From: Maria Tomalova
Sent: 23 February 2022 11:36
To: Planning.Responses
Subject: FW: F/24/21/PL
Attachments: Keith Langmead - ADC - Redstone - South Yard - Ford - CLT - Elevations - 23rd February 2022.pdf

Please replace submitted drawing 002 Rev 01 from 01/12/21 with this in attachment (002 Rev 02).
Elevations & Roof Plan E10326-GA-002 to be deleted.

Please find attached a copy of the correct elevations, with the sky lights removed, for South Yard, Ford, F/24/21/PL.

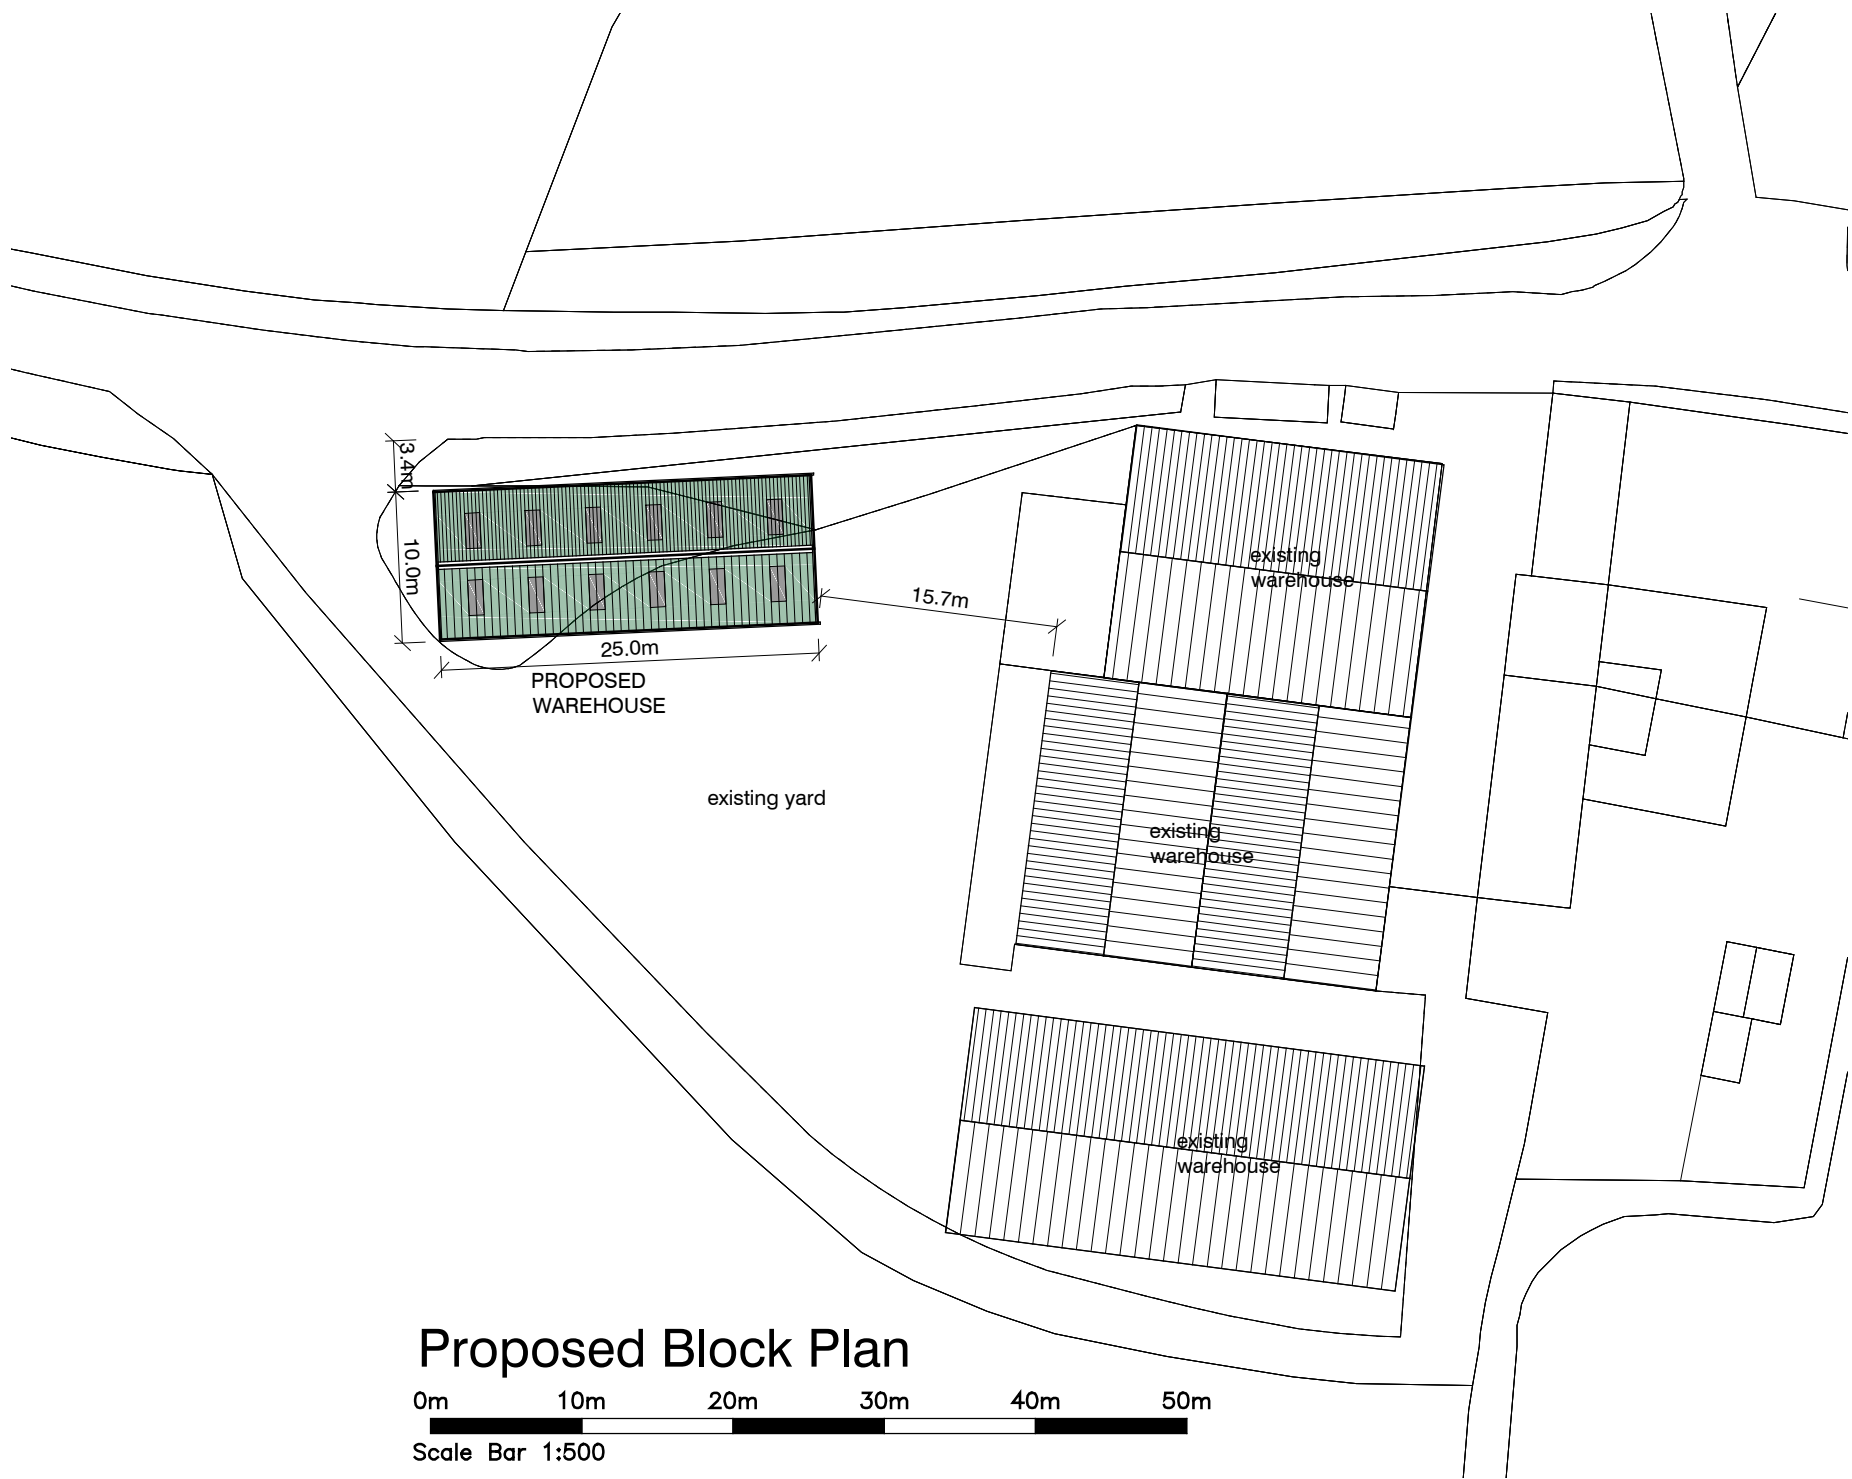
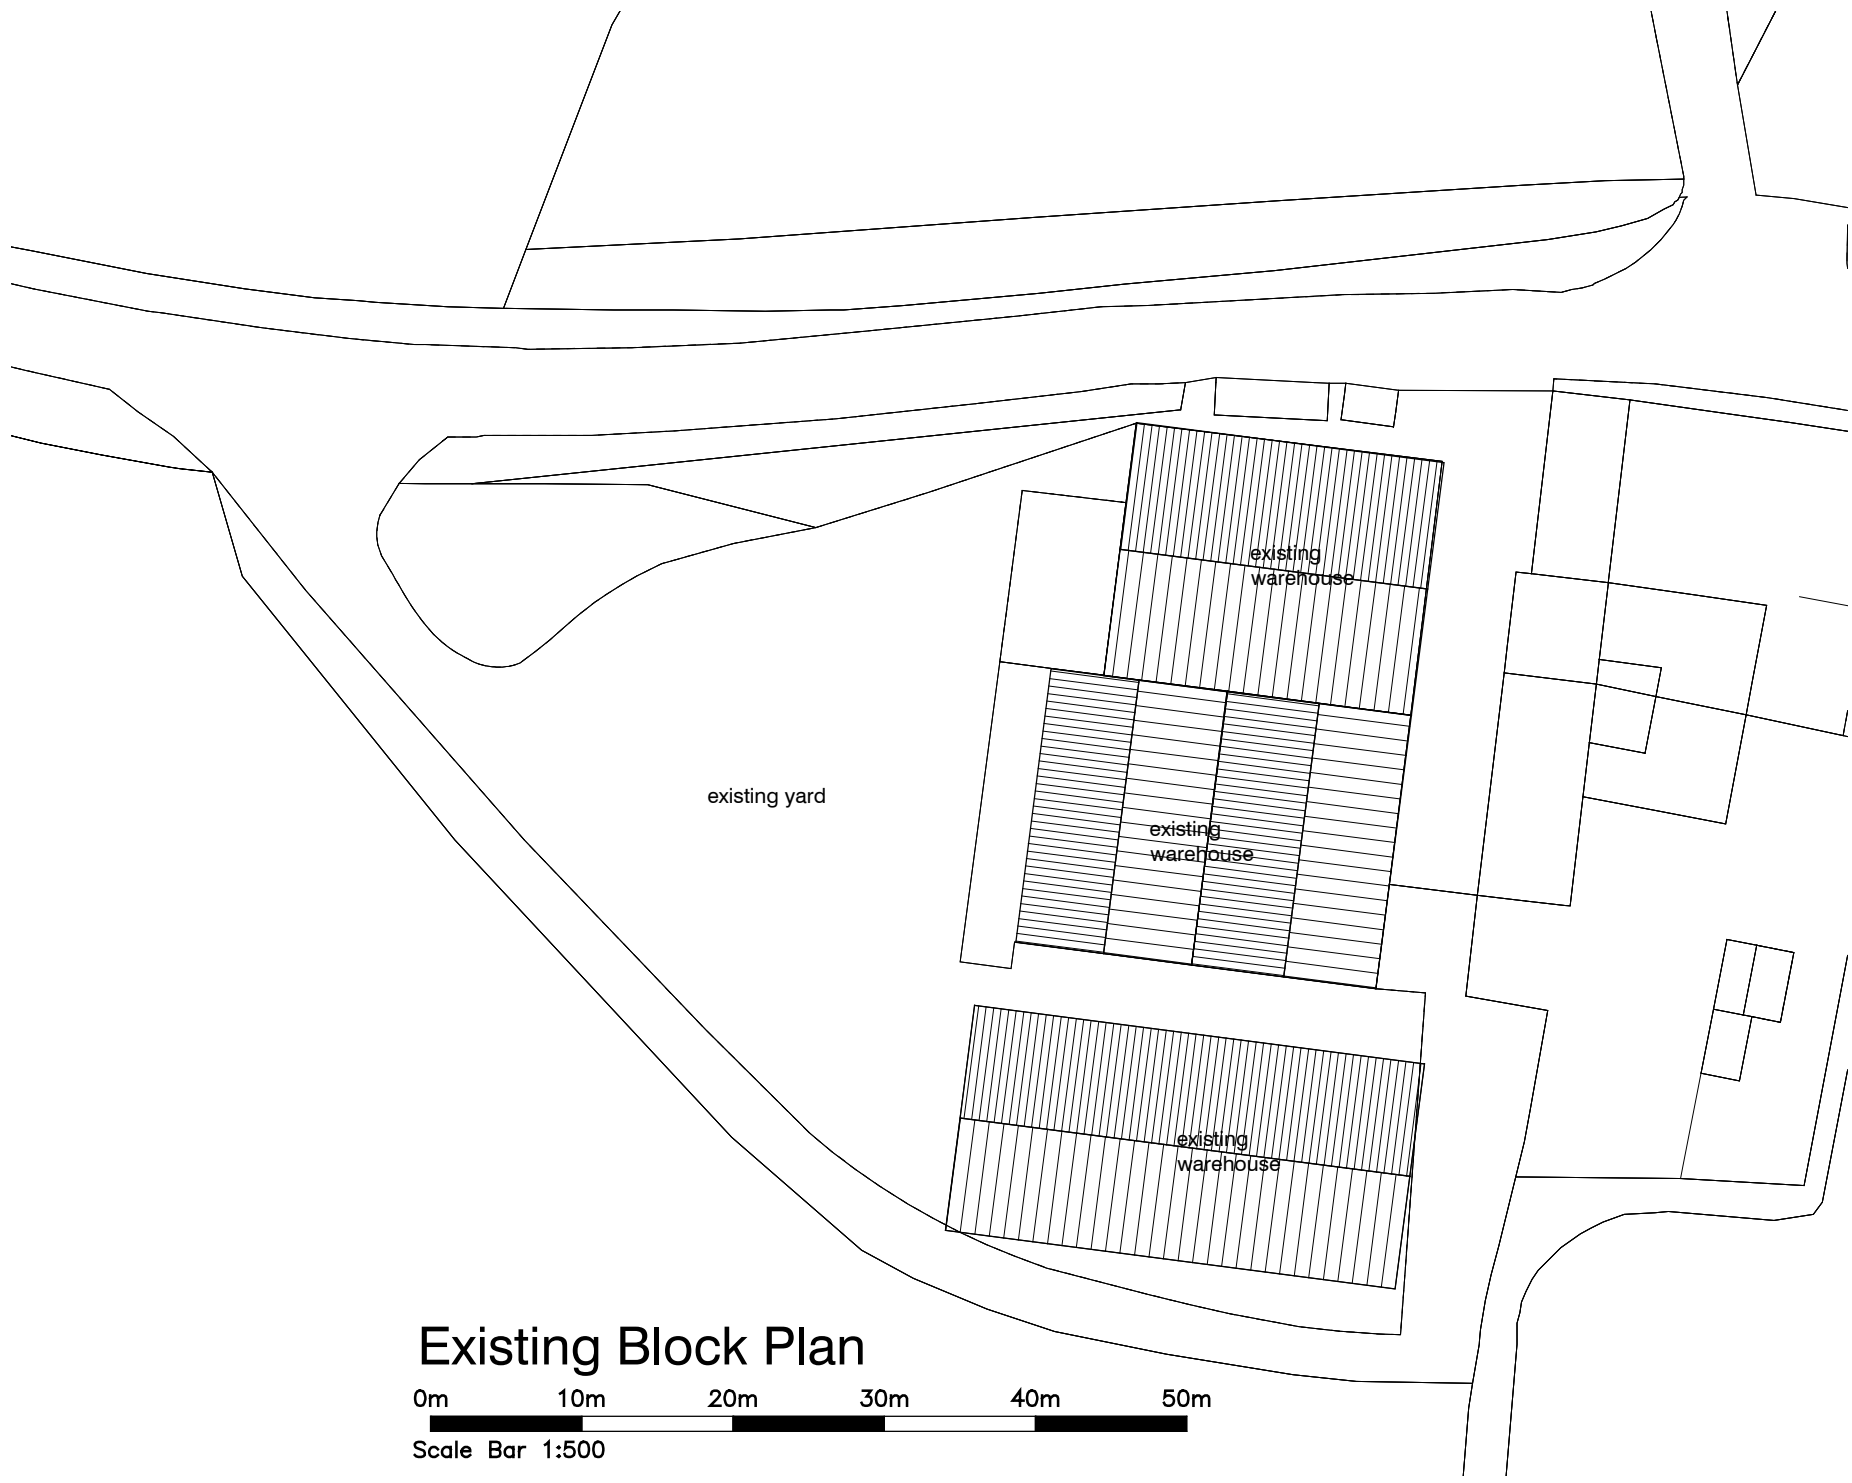
With regards to our recent phone call I am expecting from you the correct drawings; Block Plan matching Elevations & Roof Plan (ideally without a plenty of roof lights) and the confirmation of working hours.
